Application No: AL/96/21/TEL
Site Address: Corner Westergate Street and Meadow Way Aldingbourne PO20 3QT
Description of works: Prior notification under Schedule 2, Part 16, Class A for H3G phase 8 15 m high street pole c/w wrap around cabinet & 3 further additional equipment cabinets.

Thank you for your internet representation made on 13th September 2021 which has been recorded as an objection with the comments as follows:

215 PROPOSED SITE PLAN

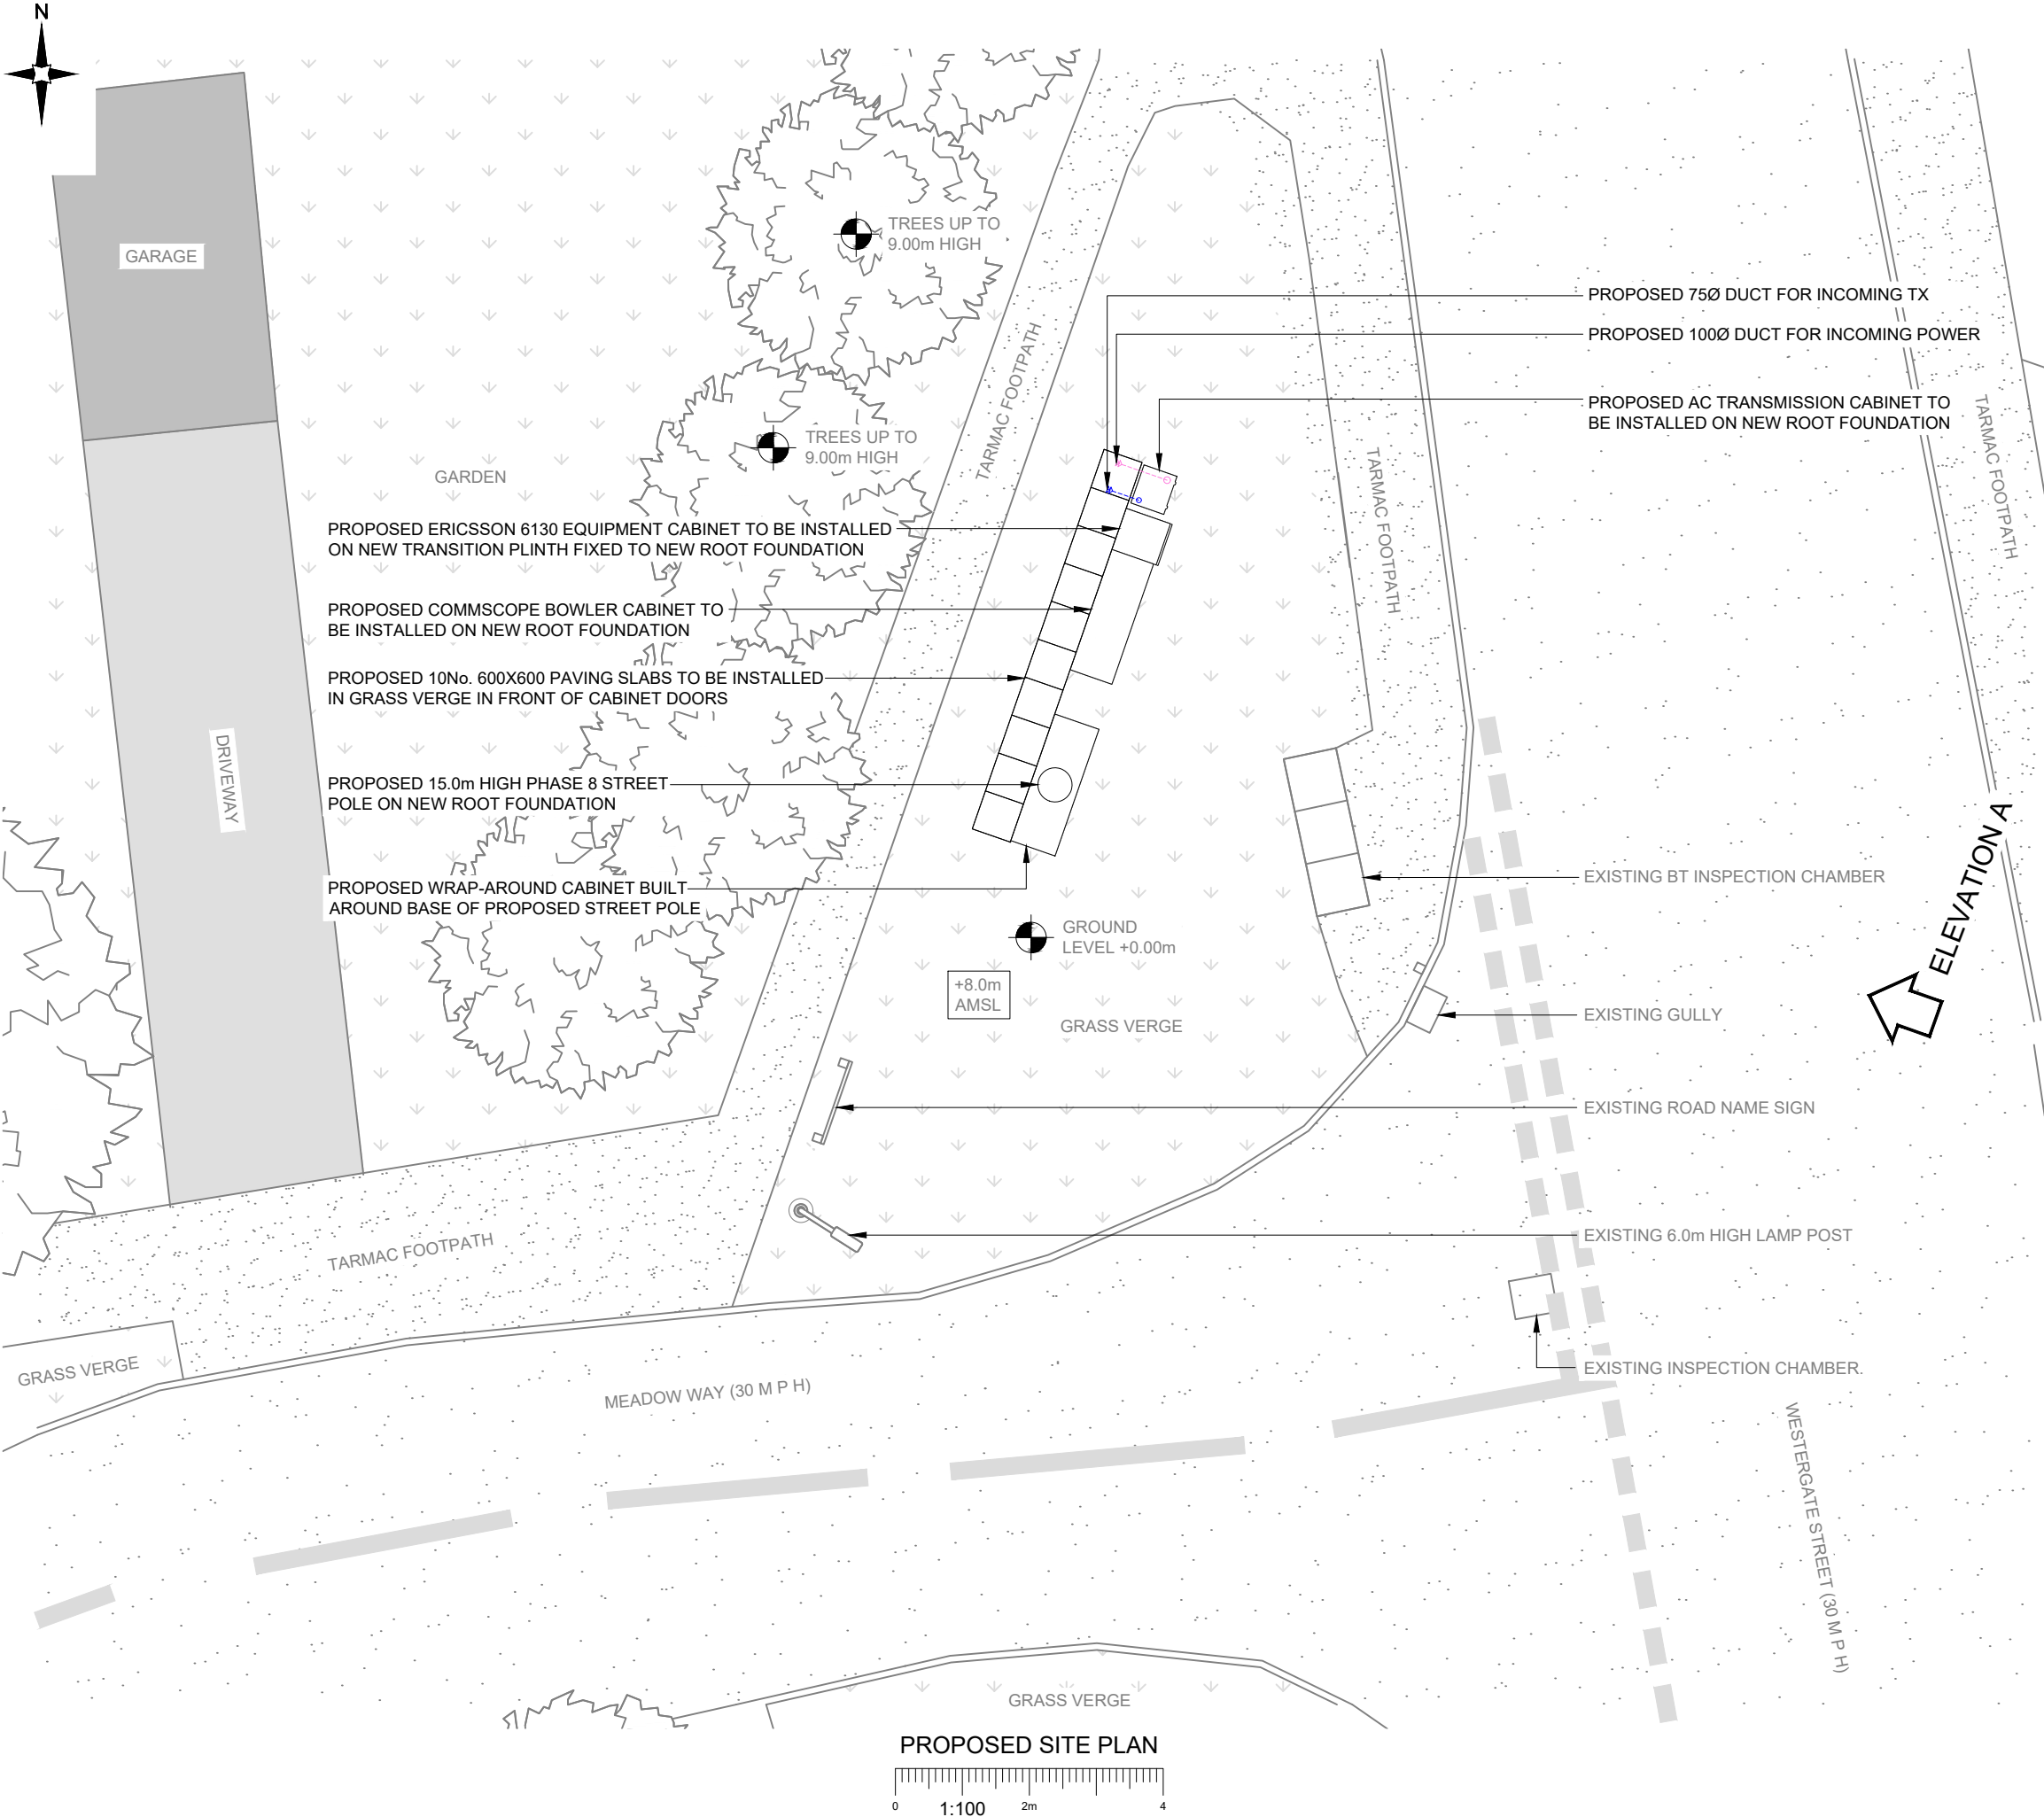
Of great concern is that the location of the mast is close to a primary school and no 'exclusion zone' for electromagnetic radiation is marked on the plan.

265 PROPOSED SITE ELEVATION

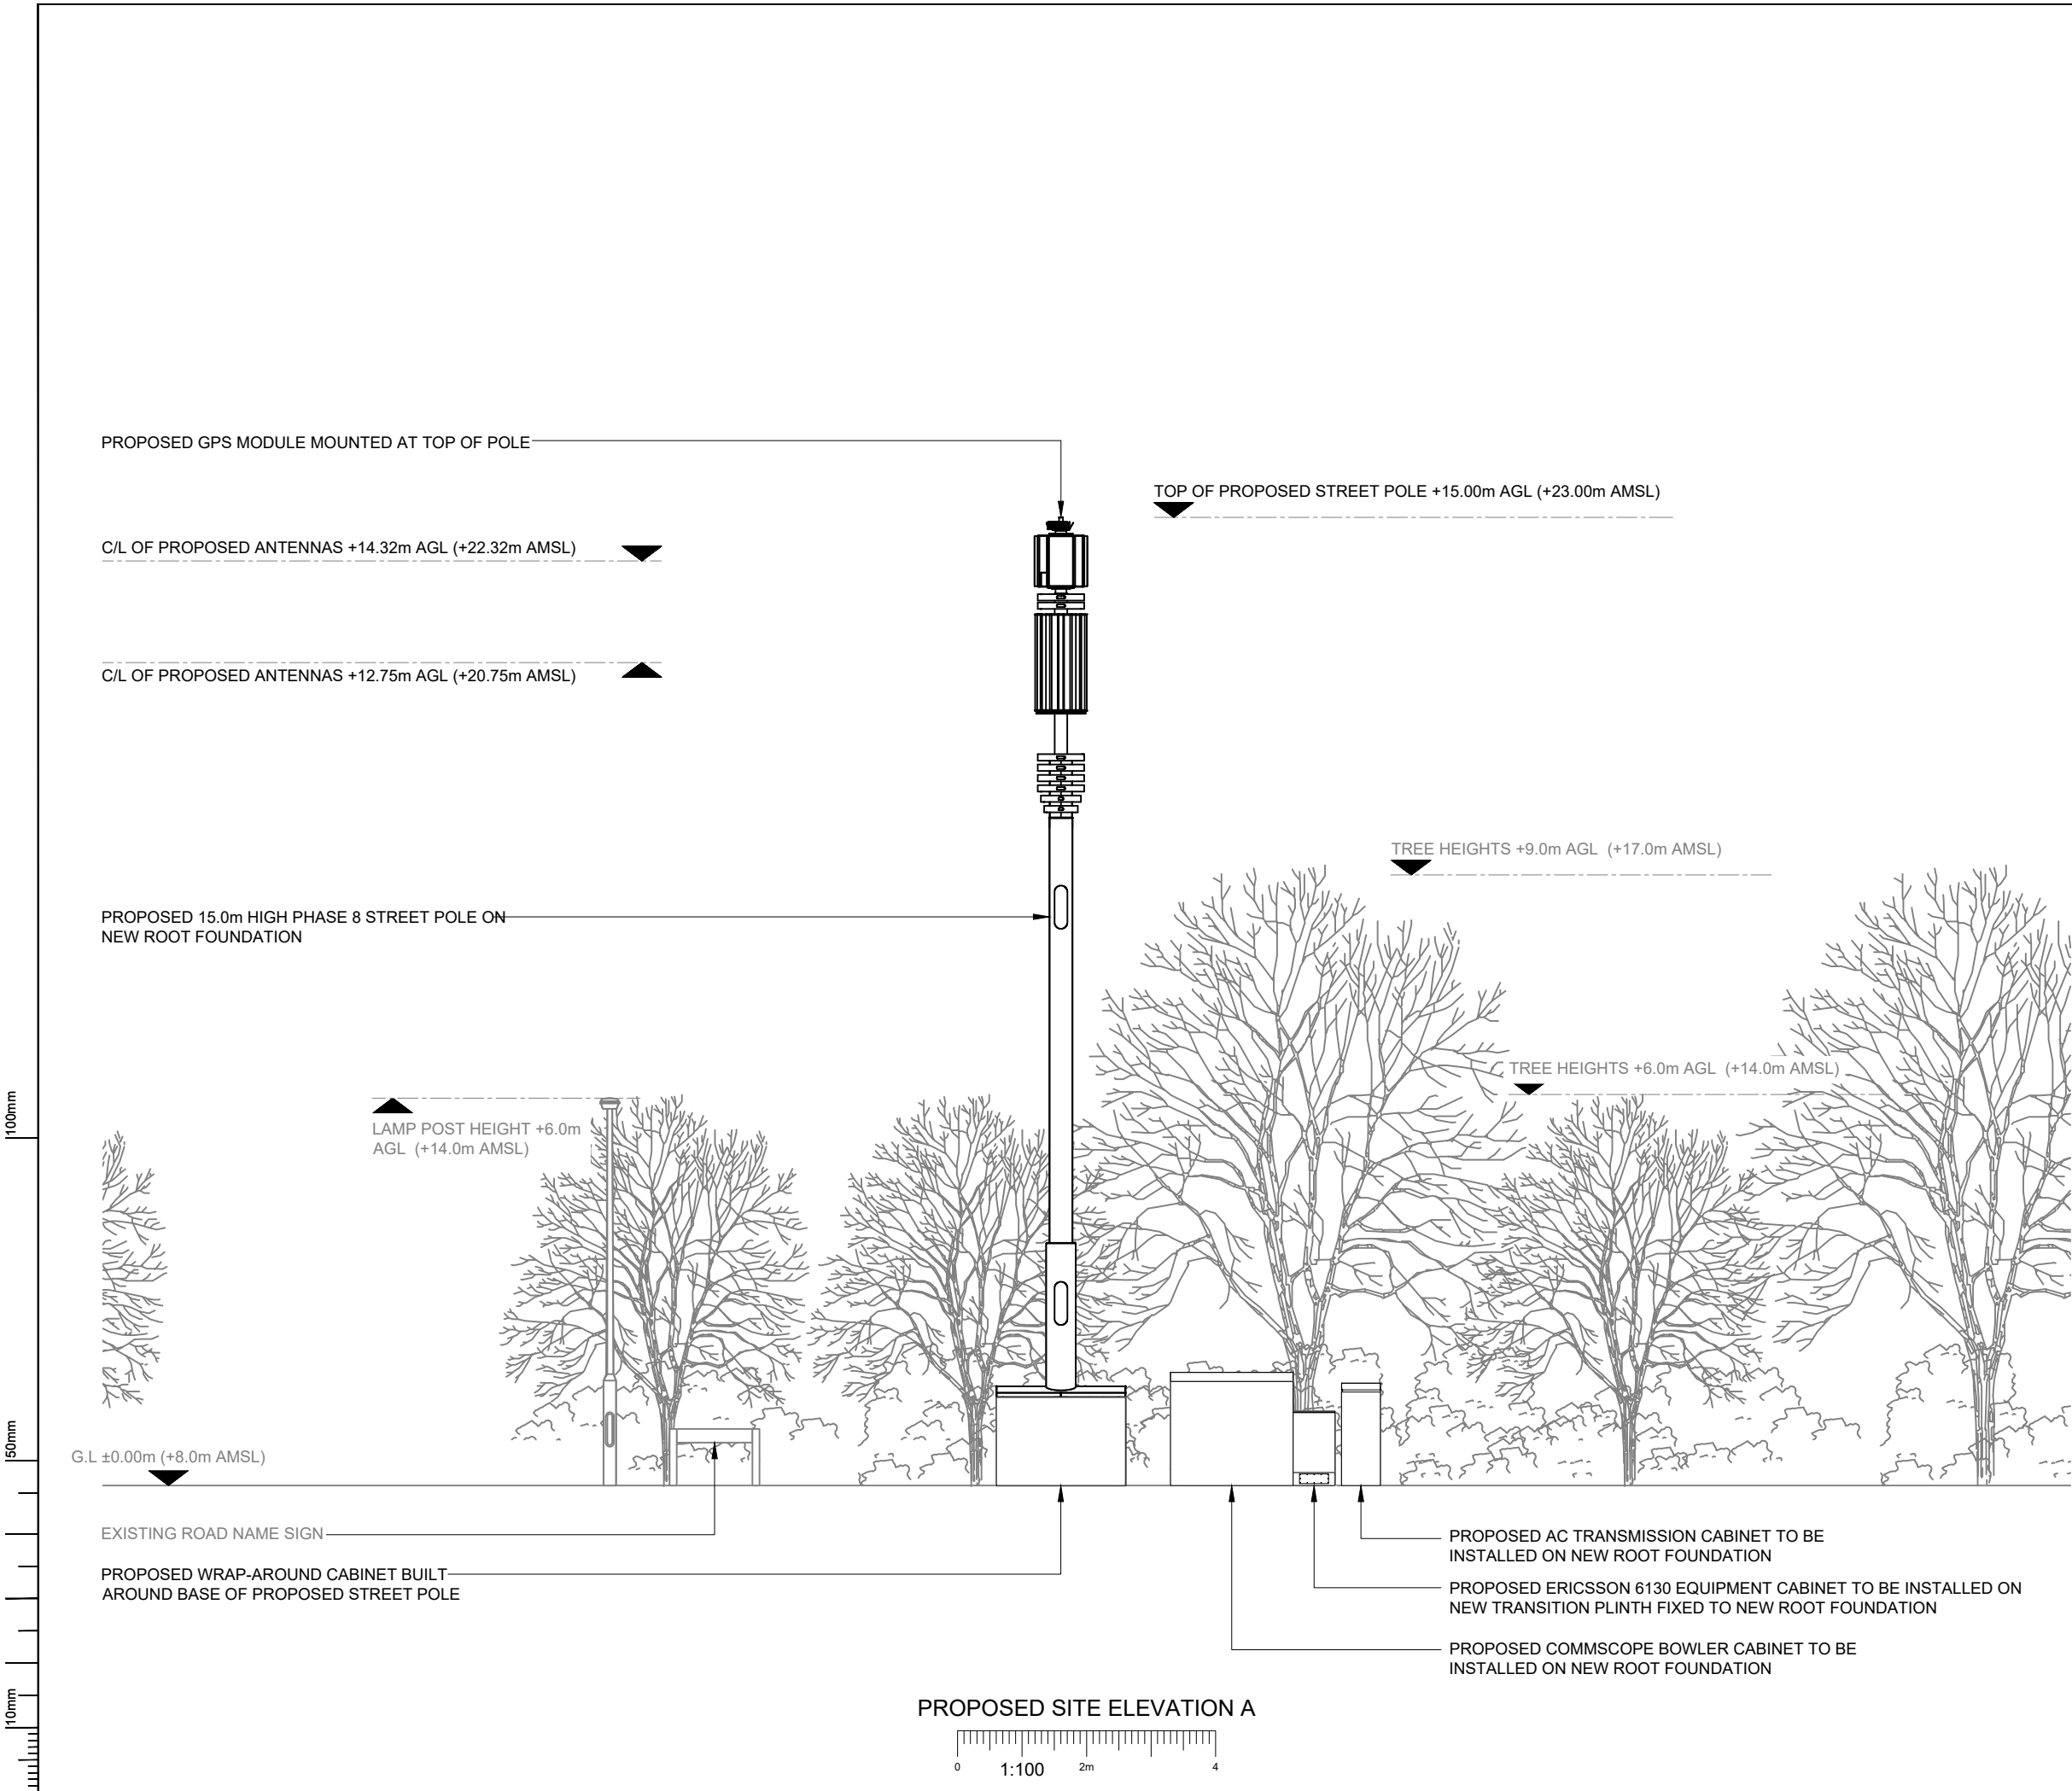
As a visitor to this area I have a number of concerns regarding this application. There are a number of anomalies associated with it. Firstly it is advertised as a pole 1.5m high when in fact it is 15m high. Secondly the 'decision by' date is 14 September but the 'comment by' date is 15 September, a day later. Thirdly the 5G Site Specific Information says that this is an 'urban setting' when in fact it is a sleepy village, showing the scant regard for the truth by Telecoms companies.

The appearance of the monopole will affect the visual amenity of the area for local residents (being very close to houses) and will seriously detract from the visual character of the area.
